Application for a non-material amendment following a grant of planning permission.
Town and Country Planning Act 1990

SINGLE STOREY PITCHED ROOF EXTENSION TO FRONT ELEVATION

R/143/16/HH

PROPOSED VIEW/A

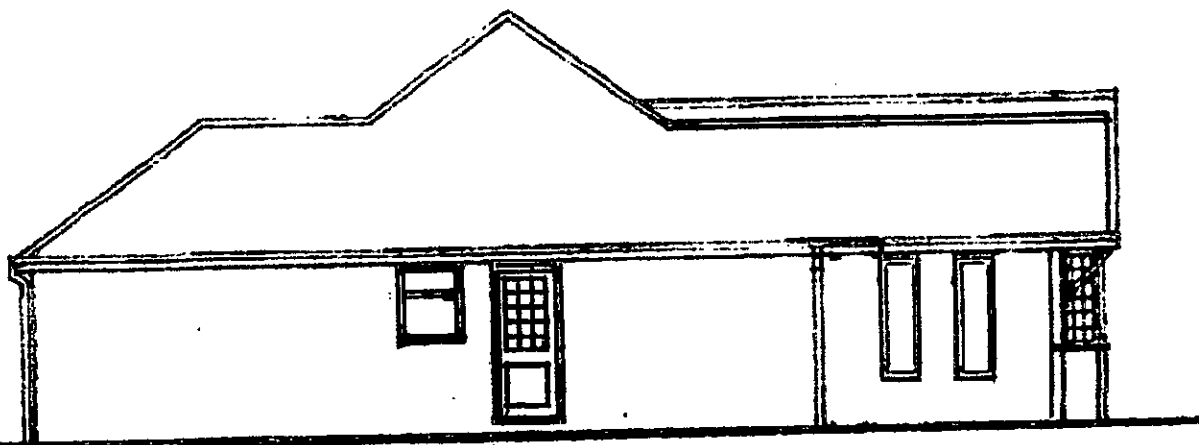
IN THE ORIGINAL APPLICATION "WE MAY ADD A PVCU GEORGIAN WINDOW APPROX. 1.5M X 1.15M TO SIDE (WEST) ELEVATION.

INSTEAD, WE WISH TO ADD 2 X NON-OPENING, WHITE FRAME WITH TOUNHEXED CLEAR NON-GEORGIAN PVCU WINDOWS EACH 0.5M WIDE X 1.6M HEIGHT
